We would like to officially comment/object to the Planning Application **3/2026/0246**.

Land at Lower Hud Lee Farm Longridge Road Hurst Green BB7 9QP

3/2026/0246 Agricultural and Design Statement:

Plan 6 showing existing retained building site (red) and Landscaping Plan area hedge/tree planting (green)

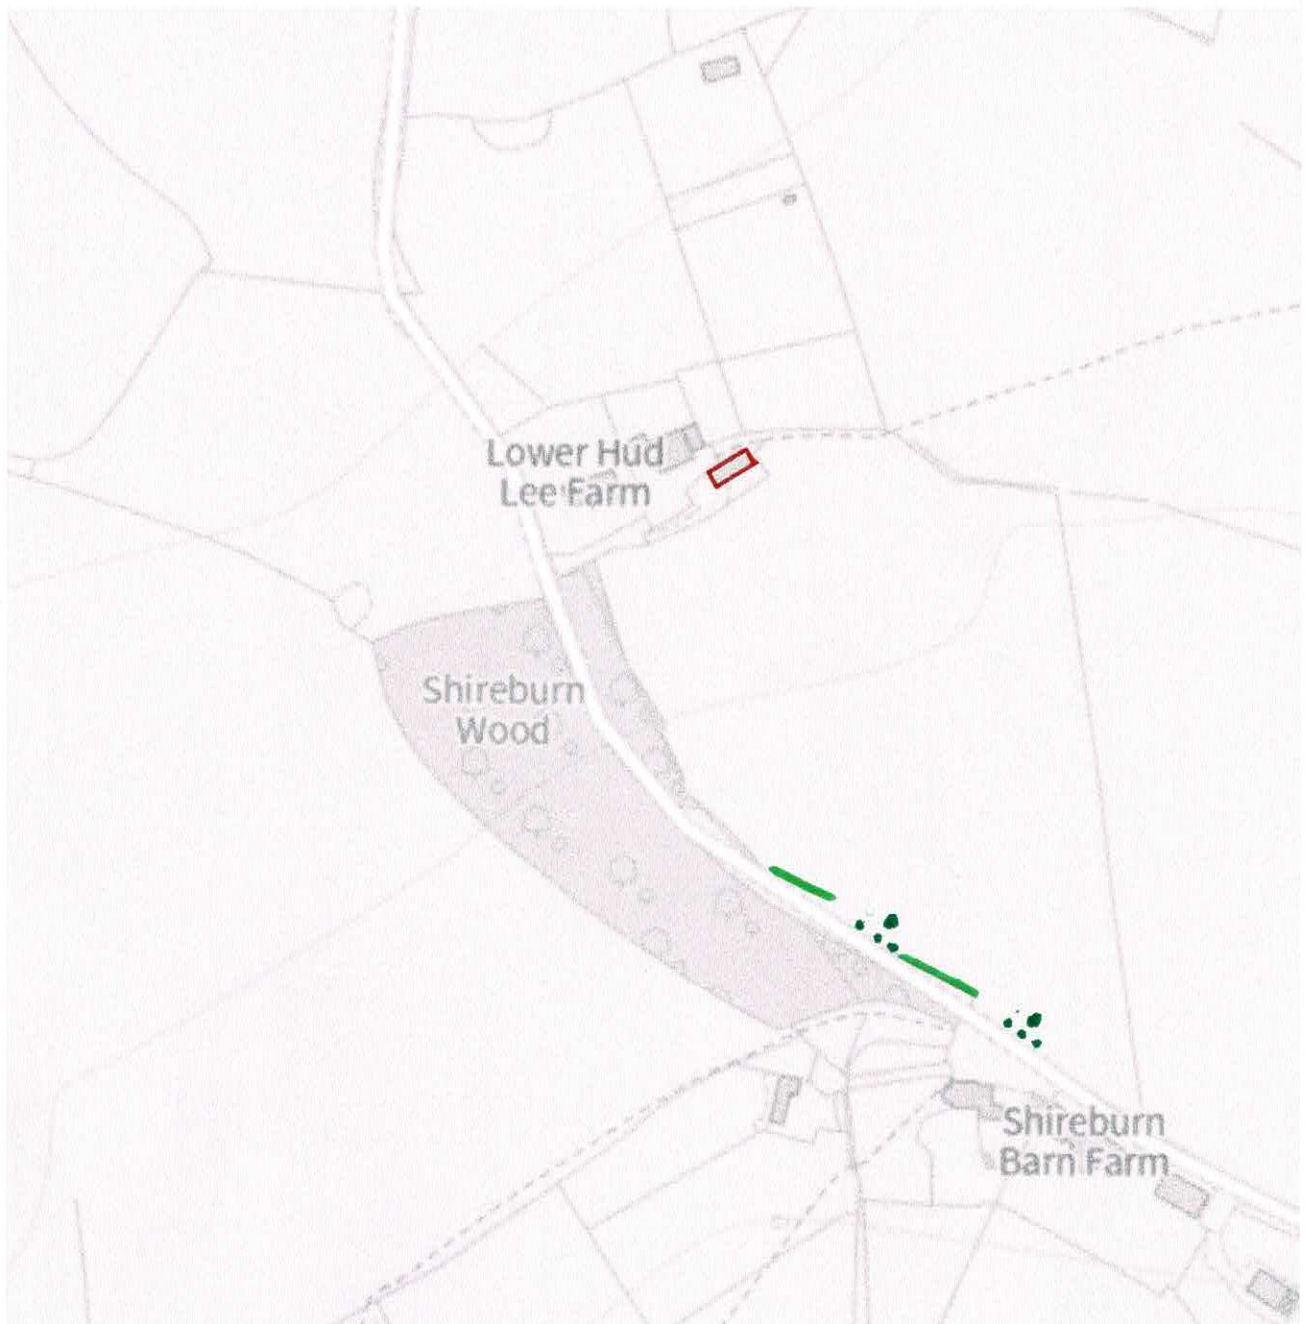
There has been repeated reference to an “**existing hard standing**” and “**access track**” at this site which is false. At no time during the purchaser's ownership of this land has there been a hard standing around this building for at least 20 years prior to that purchase in early 2023. The area around the original building and to/from the field gate from our driveway has been laid to grass since at least 1976 from an aerial photograph taken at the beginning of the Adamson House barn conversation, and publically available historic Google Earth mapping can show the same from the year 2000 (see Appendix #2).

Attempts made during building works to lay hard core and create a hardstanding/access track from the building to the field gate from our driveway prior to inspection/Planning Application were highlighted to RVBC Planning at the time and the owner was requested to cease and desist any further work (See Appendix #3). We believe the erection of a wooden poled stock fence on that grassed area in front of the building does not constitute a hard standing, existing or otherwise.

A Holt – Land at Lower Hud Lee Farm – Elevations Plan 4

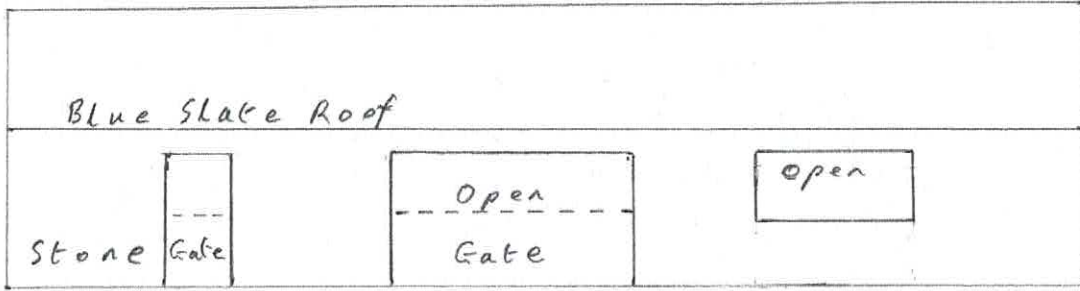
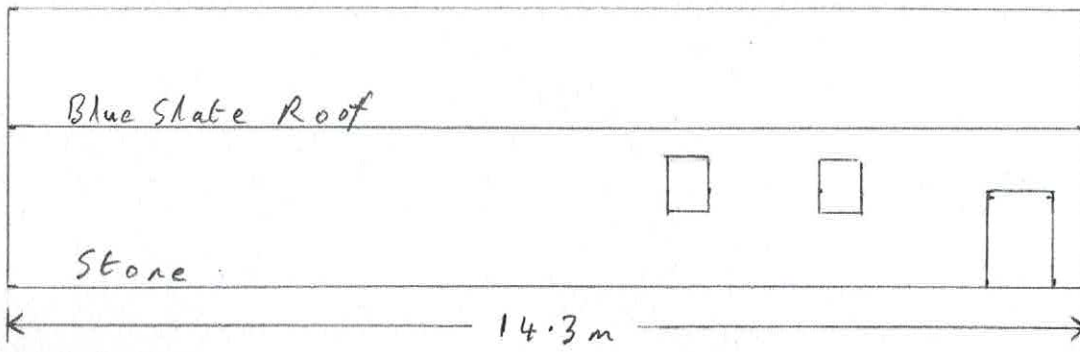
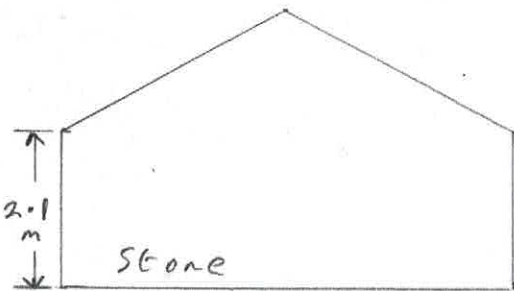
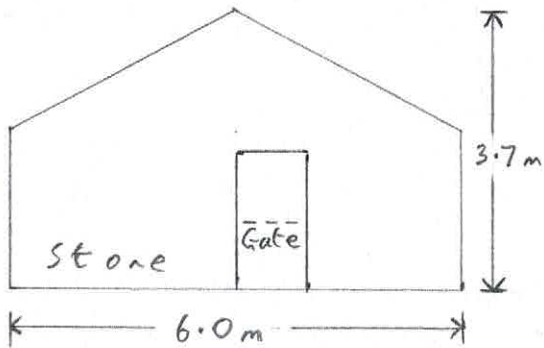
Further comments in the statement attempt to soften the impact of it's domestic appearance, large openings to the south stating requirements to provide light into the building for safe working conditions and roof and wall materials in keeping with surroundings and character of the area. We firmly believe this new configuration of the building was constructed to match plans for the dwelling conversion mentioned above, all without planning permission of any kind.

All agricultural buildings that we are aware of, including that constructed by the same family under 3/2024/0853, include significant light panels in the roof to allow light into the building, the construction of a solid slate roof in its new pitched format is more akin to a human dwelling and not for agricultural amenity.

The new building constructed has been significantly changed both in proportion and layout and as such resembles that of the domestic dwelling, demonstrated in the conversion plans applied for under **3/2024/0782**.

A Holt – Land at Lower Hud Lee Farm – pre existing Elevations Plan 4a
and former state (including original bay)

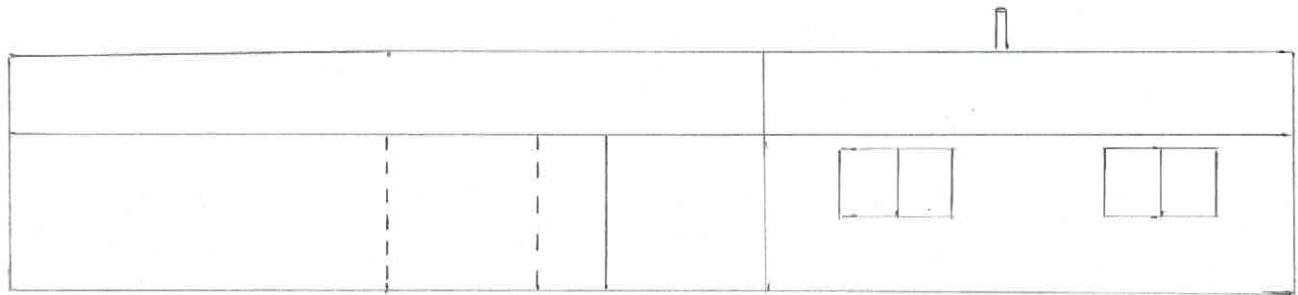
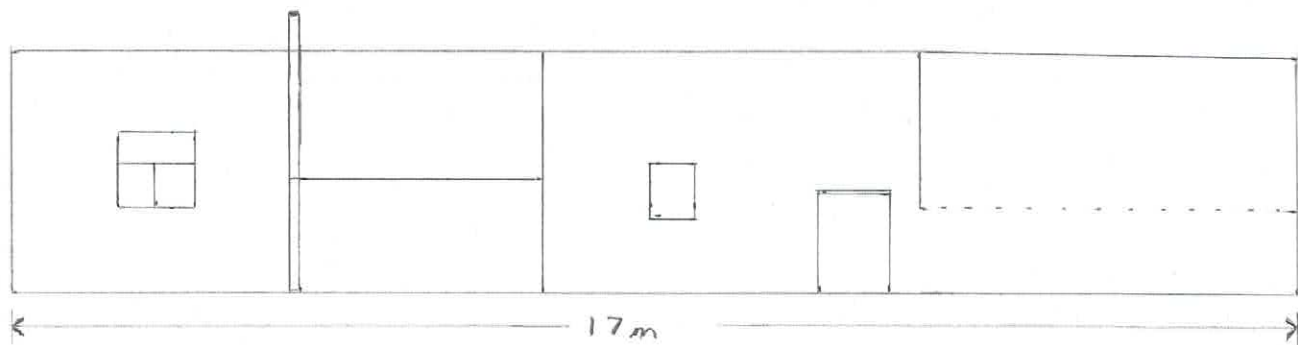
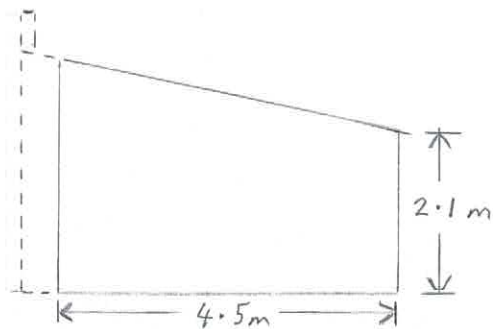
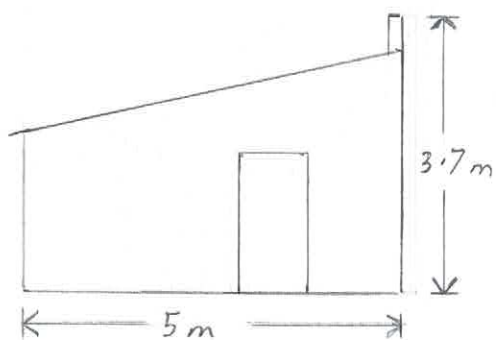
The building works that started in September 2023 included the demolition of the sheep husbandry building, the laying of enlarged concrete footings, increasing its foot print to approximately 70 square meters, changes to the layout of door and window openings and change of roof from a Pent design raising its height from 3 meters (highest pent roof height north elevation) to a Pitched design at 4.1 meters (Pitched Roof ridgeline height west elevation).

The original mono-pitched outbuilding exists now only in photographs which date back to at least 1976 where the dual stone / redbrick construction can be seen, the Armitstead Barnett tender document from 2023 and global internet mapping services.
